## KITTTITAS COUNTY COMMUNITY DEVELOPMENT SERVICES

RE: SX-18-00018 Teanaway Shoreline Exemption – Request for additional information

SITE PLAN

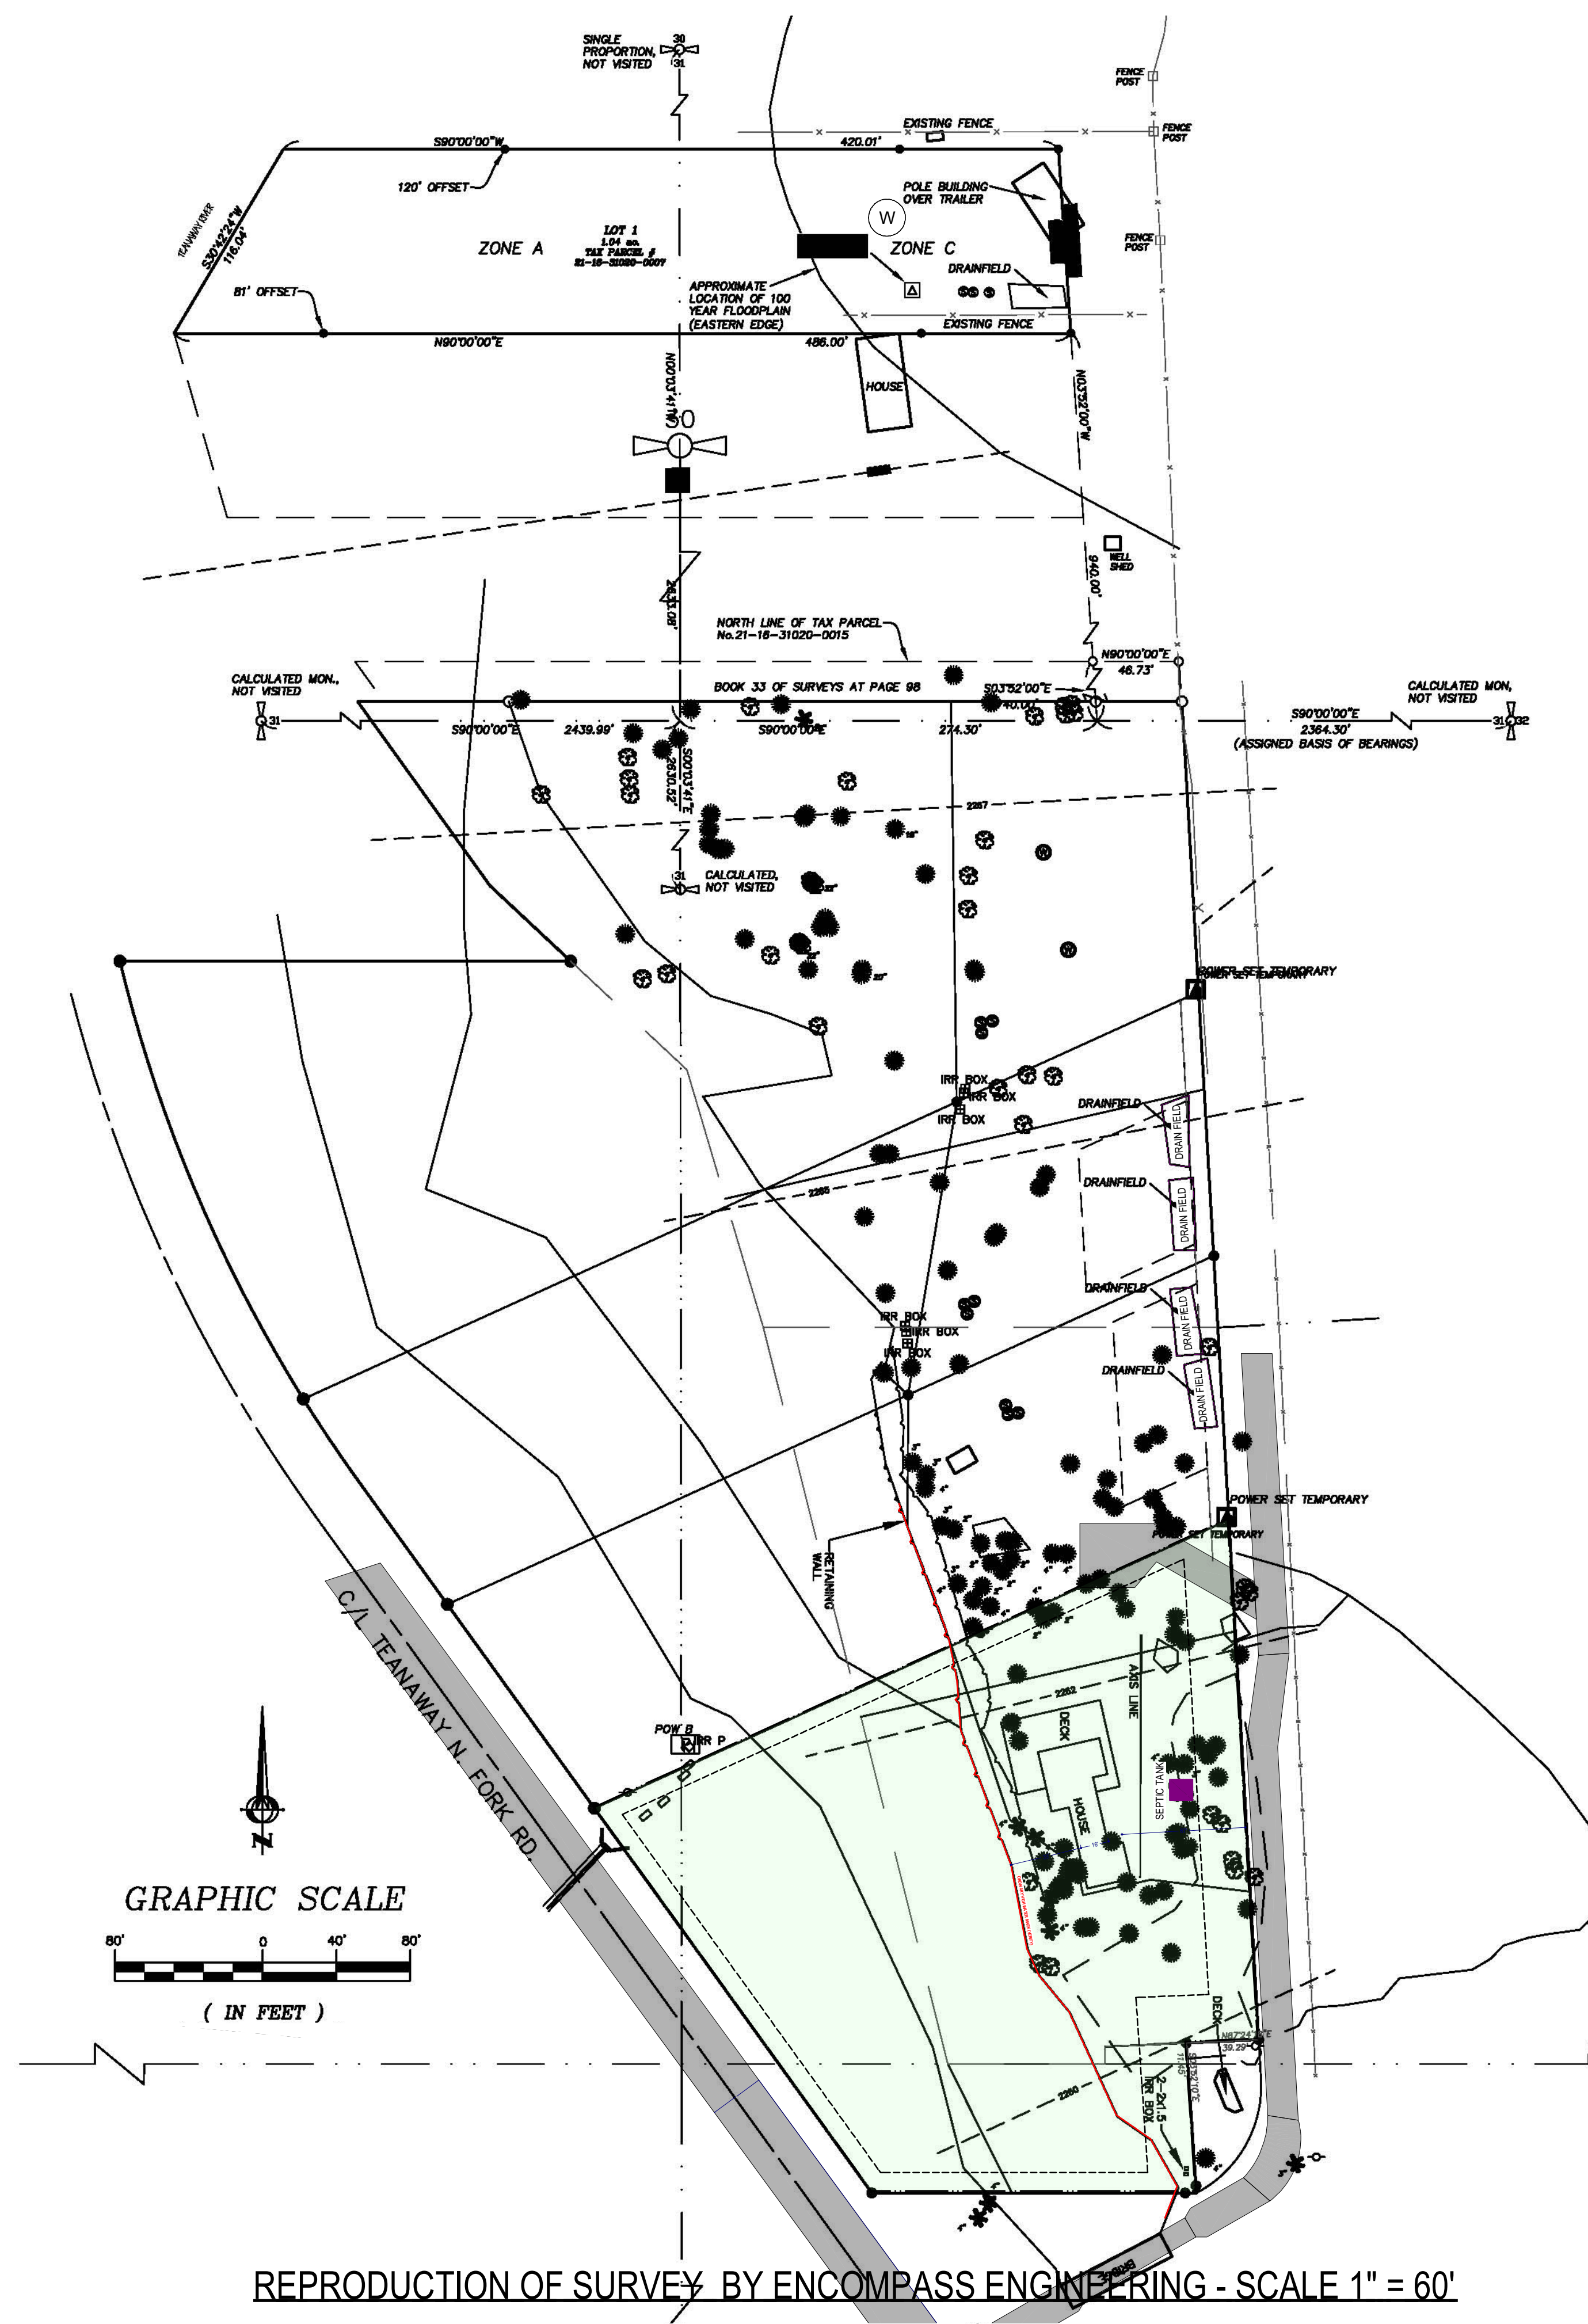
- 1) Access to the property must be clearly represented on the site plan.
- 2) The site plan includes a "future structure under separate permit." This structure would not be permitted under current Kittitas County shoreline regulations and should be removed from the site plan.

Please submit an amended site plan demonstrating the items listed above. CDS will review and process your application once this is clarified.
